### **HYDRO-ENVIRONMENTAL SERVICES RESPONSE**

Date: 6<sup>th</sup> November 2025  
Our Ref: P1508-1-0001

**Re: An Coimisiún Pleanála Third Party Submissions Response regarding Clonberne WF Grid Connection Co. Galway (ABP Ref: ABP-320087-24)**

Drawing No: P1508-0-0624-A1-D101\_GC-00C

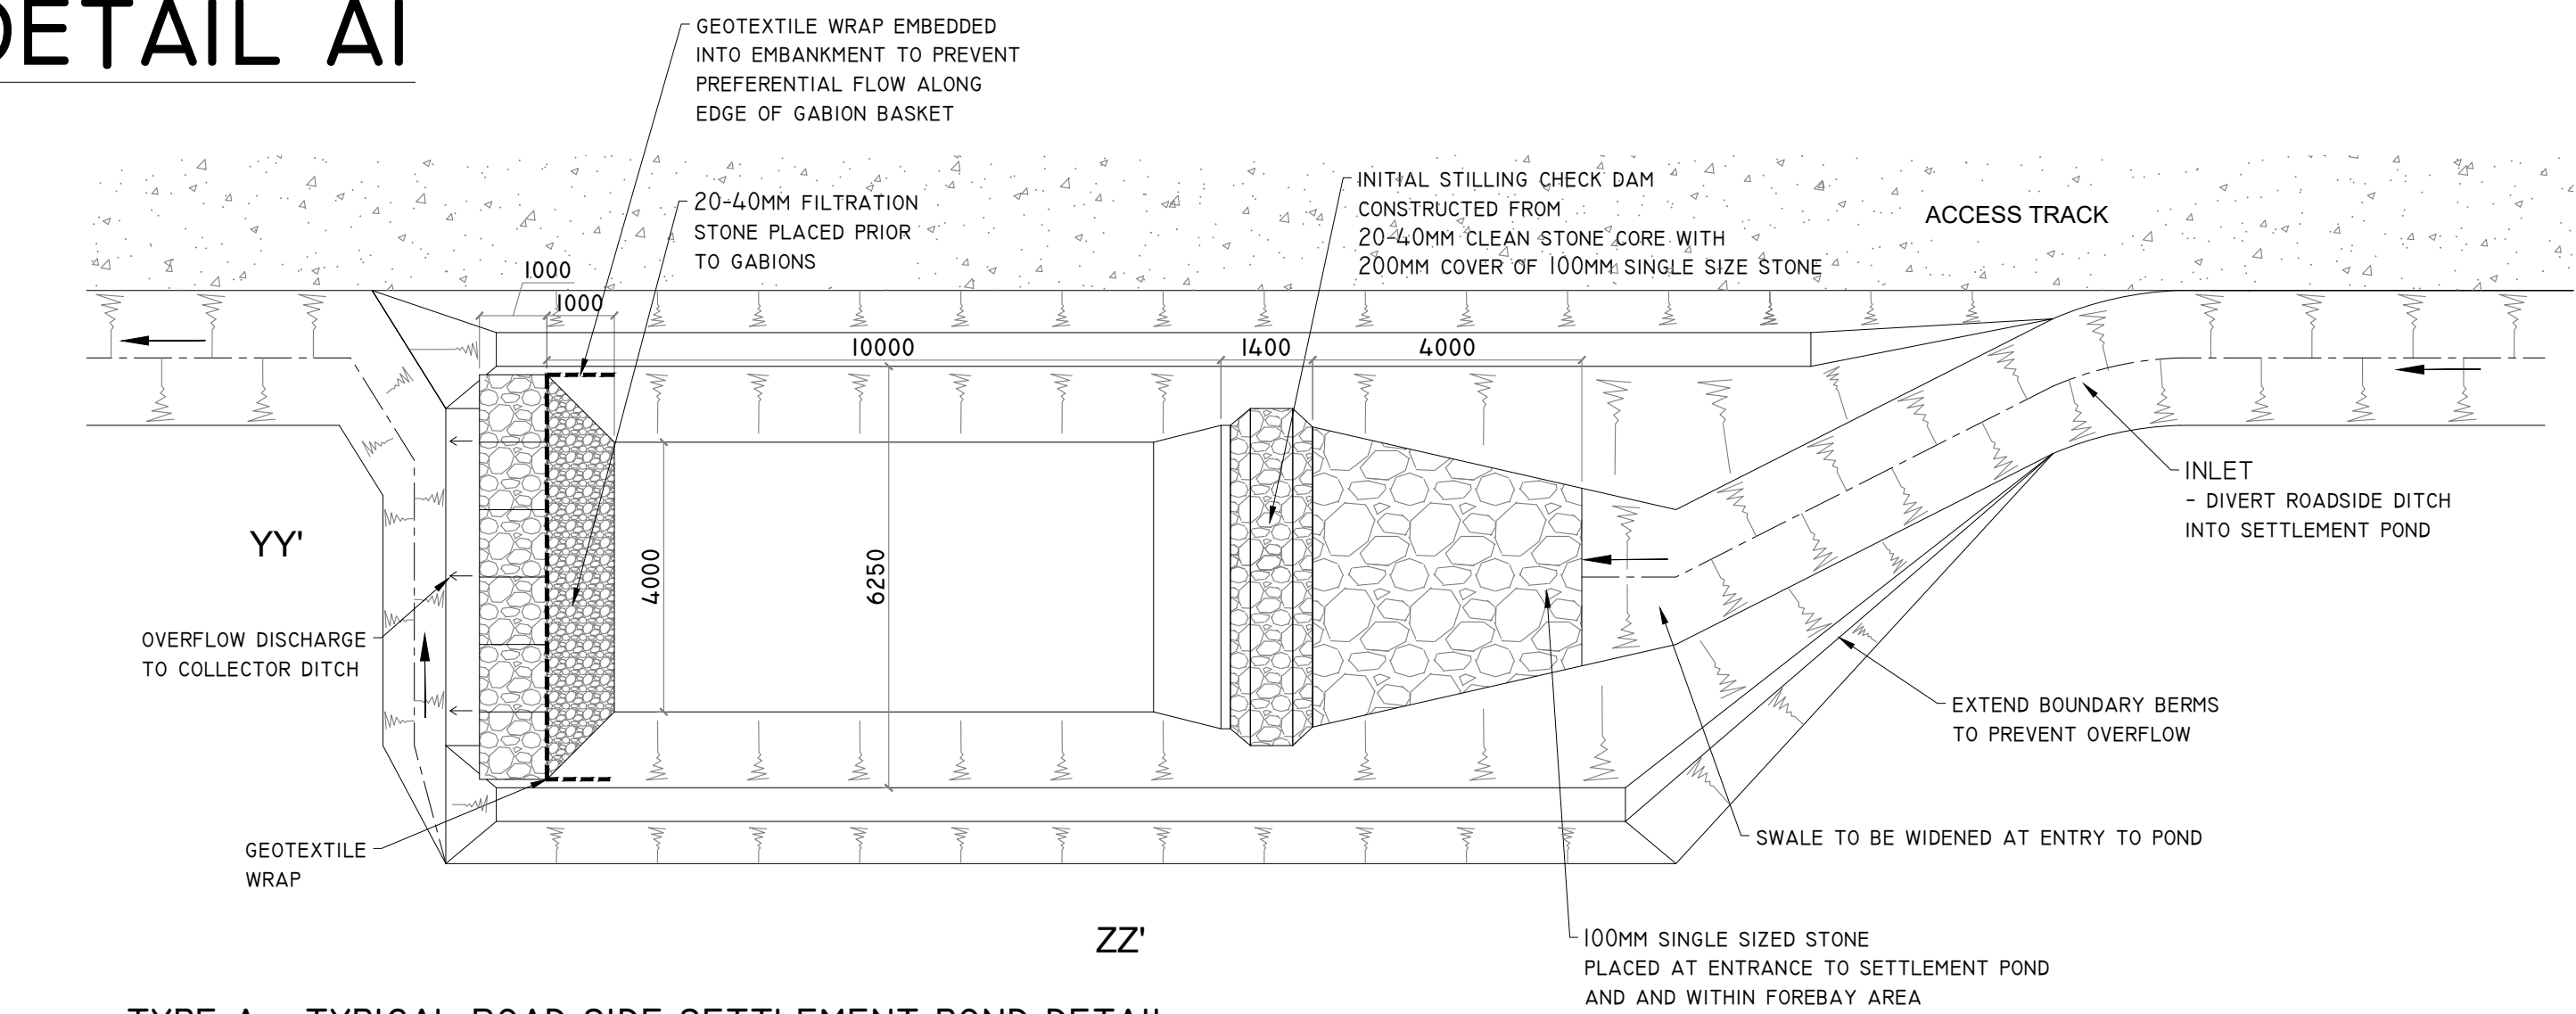
*"The grid connection infrastructure which connects to the national electricity grid via a loop-in connection into the existing 220kV Cashla – Flagford overhead line in the townland of Laughhil is a major hydrological concern. The 220 kV transmission line will be broken between tower 87 and 88 and the two loop-in towers shall be built to turn the existing transmission line into two gantries within the two cable compounds and two new steel masts".*

*"Both gantries, both masts are being constructed in an area of somewhat extreme and high groundwater vulnerability. No additional boreholes were drilled in this area. Take note of the proximity to the Levally Stream which borders this area on almost all sides. This area is hydrologically connected to Lough Corrib SAC and is a regionally important aquifer".*

*"There is no mention of this area in the hydrology report. No section was provided to outline the potential groundwater effects associated with four infrastructural elements in this sensitive area each with deep concrete foundations".*

Firstly, a 220kV overhead line already exists at the proposed loop-in location, including two existing large lattice towers which are constructed very close (with the same ground conditions) to the proposed Grid Connection end mast locations. The construction method used for the existing lattice towers will be very similar to the proposed end masts (i.e. localised earthworks and foundation construction over a very short period).

Overhead line supporting structures, such as the Grid Connection proposed end masts, can be constructed at this location without causing significant environmental effects as proven by the presence of the existing towers.

The GSI mapped subsoil geology at the proposed end mast locations is limestone glacial tills as was confirmed by walkover surveys and carrying out soil cores (refer to Table 8-6 of the EIAR).

As stated in the Section 8.3.4.1 of the EIAR, there are no GSI karst features mapped in the area nor were there any observed during walkover surveys.

In addition, the mitigation proposed in the EIAR regarding earthworks (Section 9.5.2.3), excavation dewatering (Section 9.5.2.5), hydrocarbons (9.5.2.6) and cement-based compounds (Section 9.5.2.8) also apply to the Grid Connection element of the Proposed Project including the end mast works. All potential effects associated with the end mast construction have been considered and mitigation has been provided in the EIAR.

Also, the proposed drainage control measures which are described in Section 9.4.1 will also be applied to the end mast location as shown on drainage plan drawing P1508-0-0624-A1-D101\_GC-00C (Appendix 4-5 of EIAR).

With regard the comment on the proximity of the Levally Stream, it needs to be pointed out that the Levally Stream is located ~1.2km to the southwest of the end mast location and does not 'border this area on almost all sides' as stated in the submission.

Finally, the end mast locations are at a ground elevation of approximately 83m OD with the elevation of the Levally Stream (Lough Corrib SAC) being much lower, close to 68m OD. Therefore, the proposed ground works at the end mast location will have very low potential to effect groundwater flow paths towards the Levally Stream due to the large elevation difference and indeed setback distance.
